# A428 Black Cat to Caxton Gibbet Road Improvement Scheme

Planning Inspectorate reference: TR010044

## Joint Written Representations

Document reference: CLA.D1.WR

**Figure 1-1: Location of Coton village**

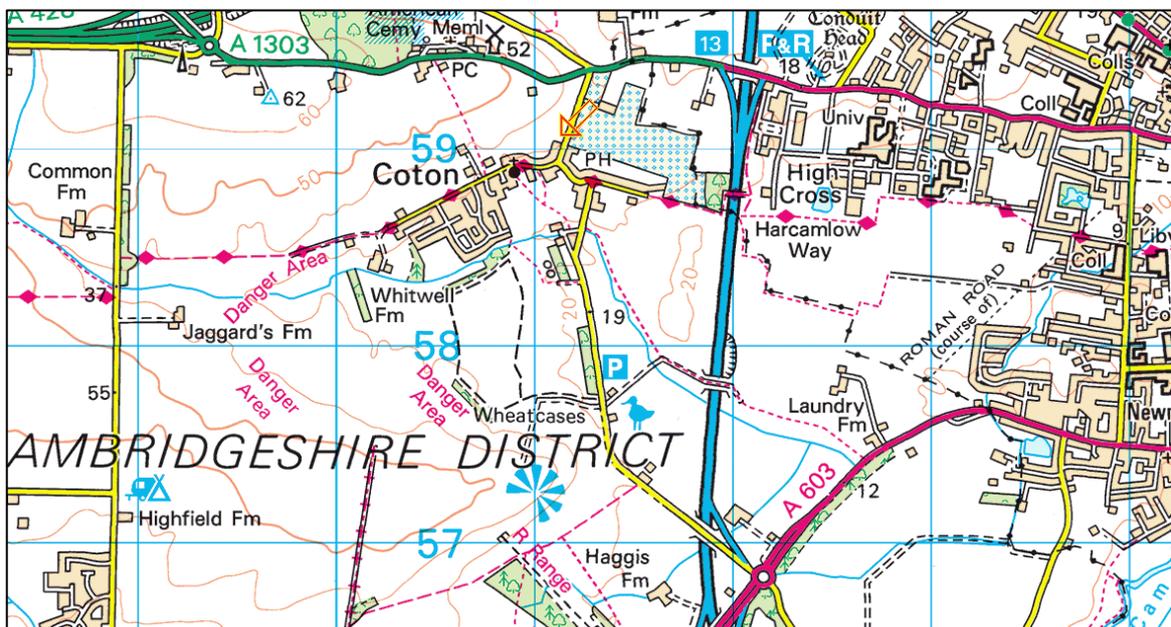
- 2.3.1 No traffic travelling eastbound between the A428 and M11 southbound is using M11 junction 13 in the morning peak. This traffic instead cuts through Coton and this effect is likely due to modelled congestion on the M11. In reality this routing is unlikely due to the nature of the road through Coton, which is narrow and subject to a number of different speed limits. This issue is present in the base year model and this is not supported by the available count data. Therefore this is a movement that is not being made in the base year but is a result of the congestion in the model on the M11. This effect is amplified in the forecast year scenarios. Instead, traffic looking to head south down the M11 continues along the A1303 Maddingly Road and uses M11 J13. An updated model is required.

- 2.4.4 Coton – all traffic travelling between A428 and M11 in the model avoids using M11 junction 13, instead travelling through Coton. This is due to modelled congestion on M11 between junctions 12 and 13 causing traffic to route on an unsuitable minor road. This is not a movement seen in the available traffic data. As this is a result of the coding of the M11 in the model HE need to monitor traffic levels through Coton to show that in reality this suggested impact of the scheme is not happening in reality.
